# OXFORDSHIRE COUNTY COUNCIL'S RESPONSE TO CONSULTATION ON THE FOLLOWING DEVELOPMENT PROPOSAL

**Application no:** 21/03267/OUT

**Proposal:** Outline planning permission (all matters reserved except for access) for the erection of buildings comprising logistics (Use Class B8) and ancillary Office (Use Class E(g)(i)) floorspace and associated infrastructure; construction of new site access from the B4100; creation of internal roads and access routes; and hard and soft landscaping

**Location:** South East Of Baynards House Adjoining A43, Baynards Green

BOUNDARY SECTIONS 11-15

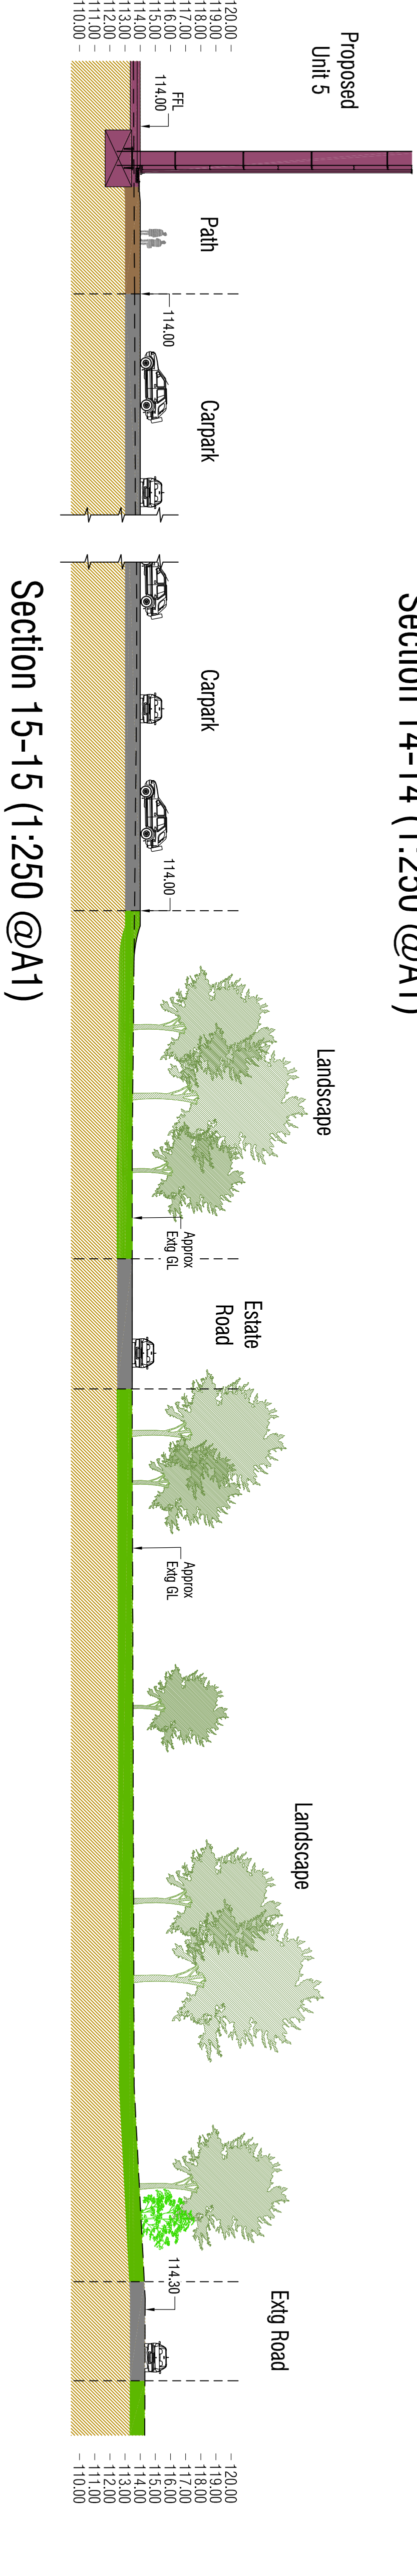
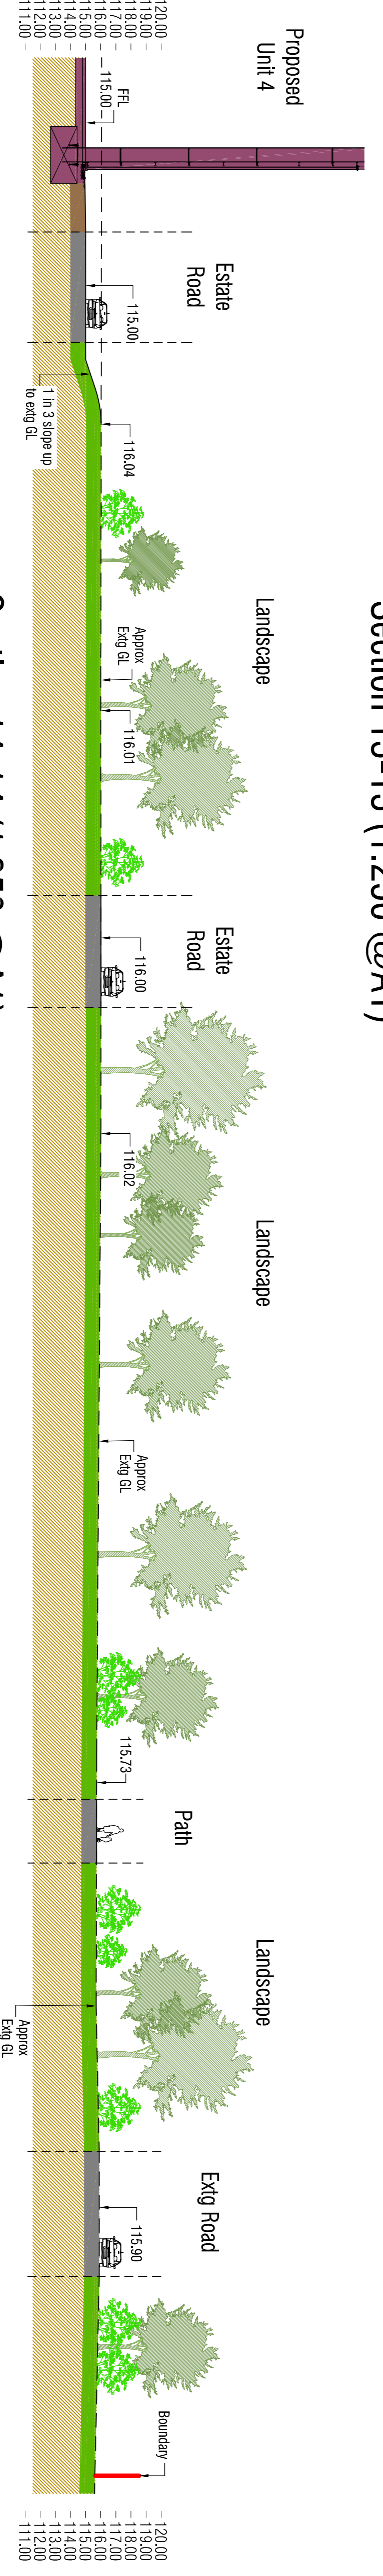
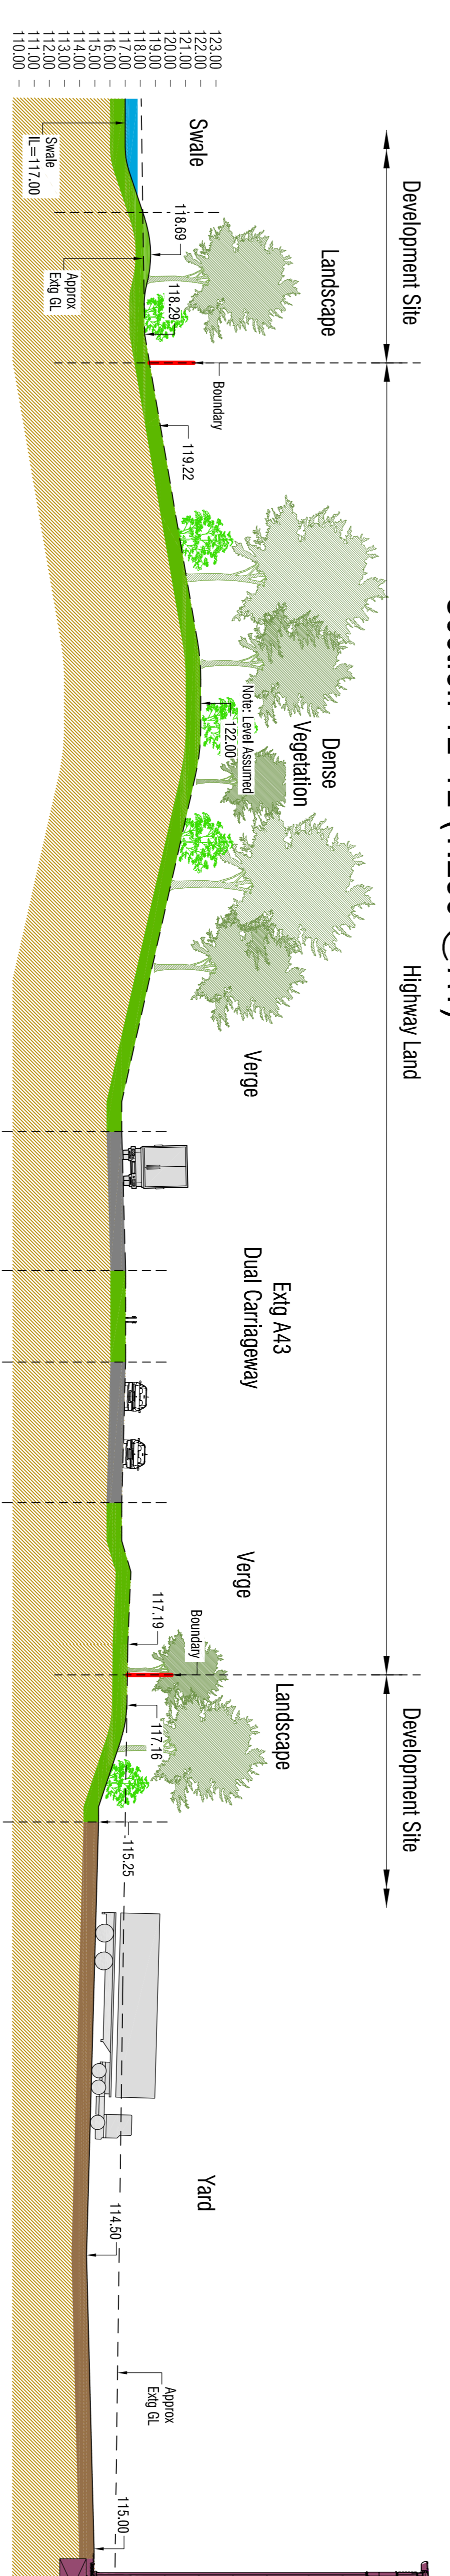
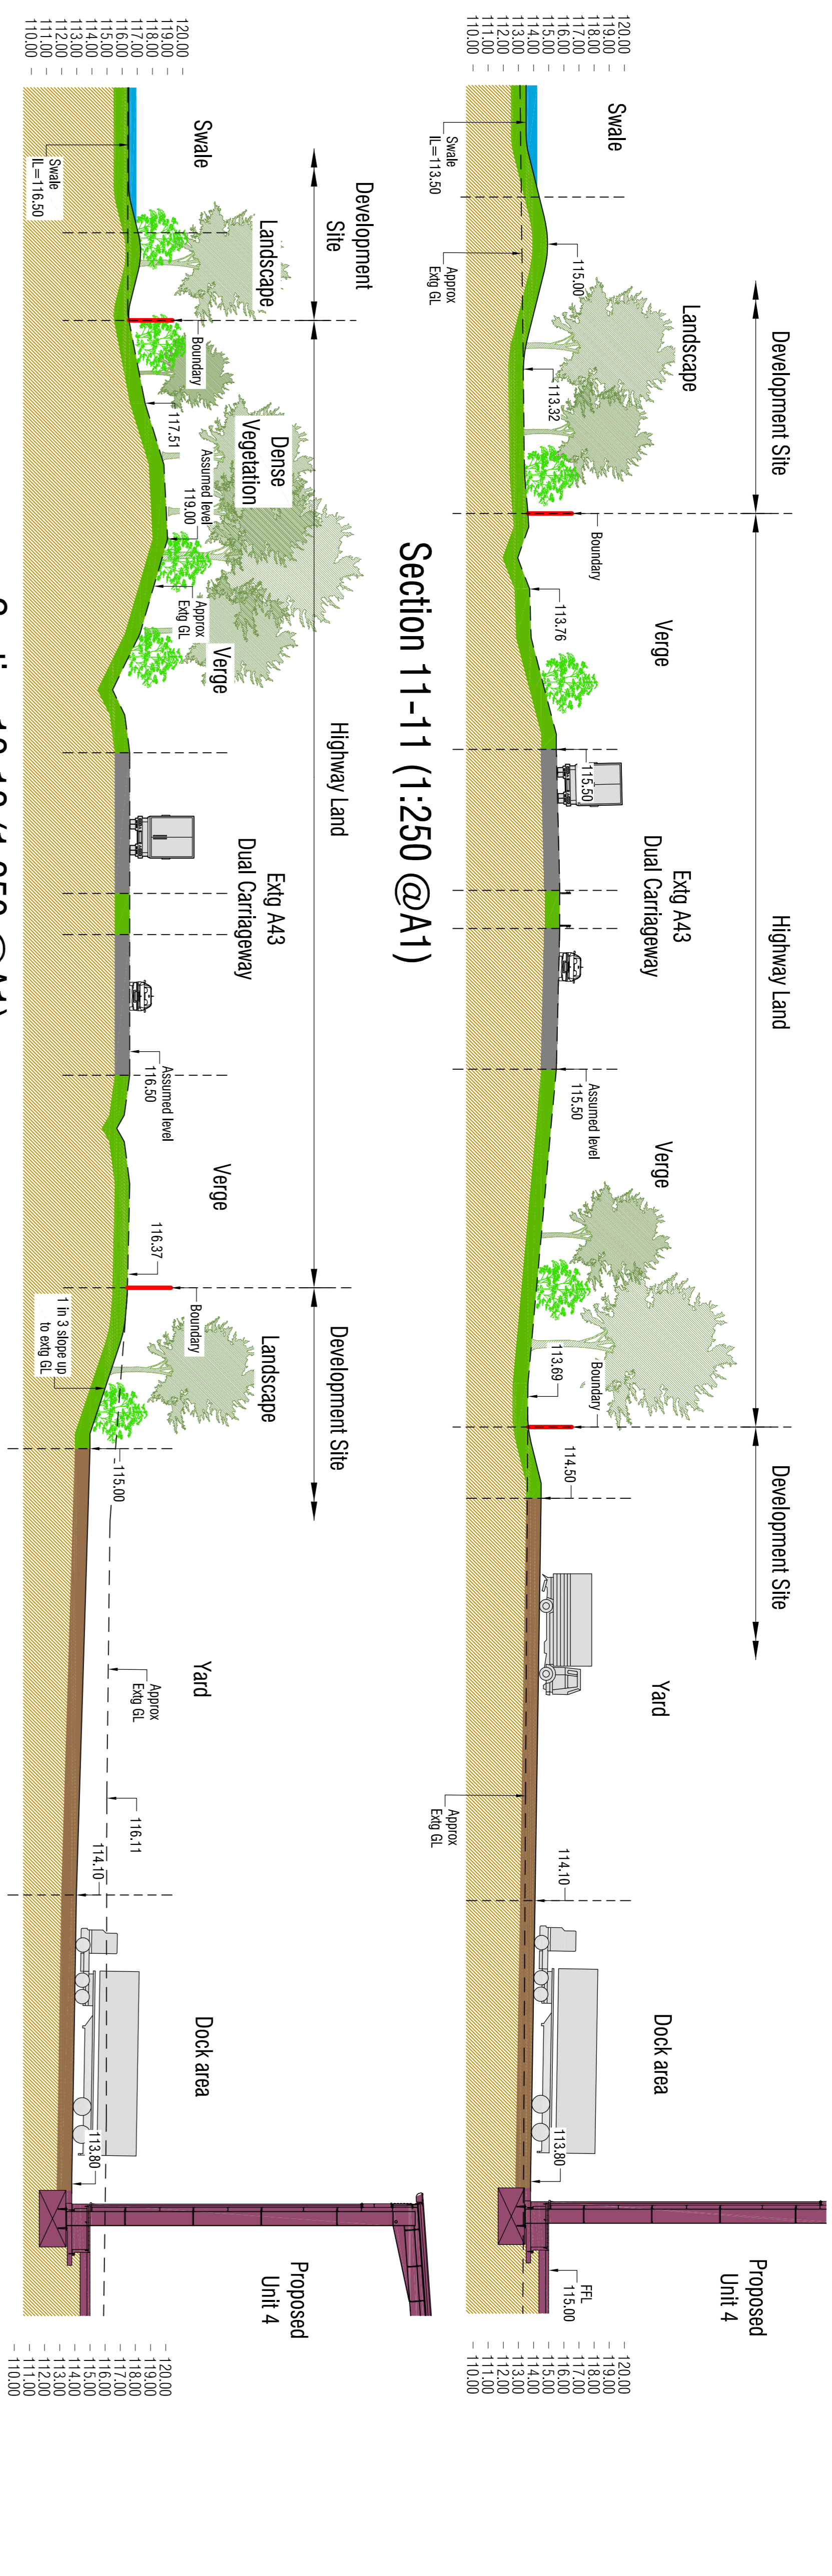
The further information also includes proposed cross sections which include alterations to the public highway. The Highway Authority reserves its position on these, pending agreement of the proposed highway arrangements, which are not approved (please see our previous consultation response).
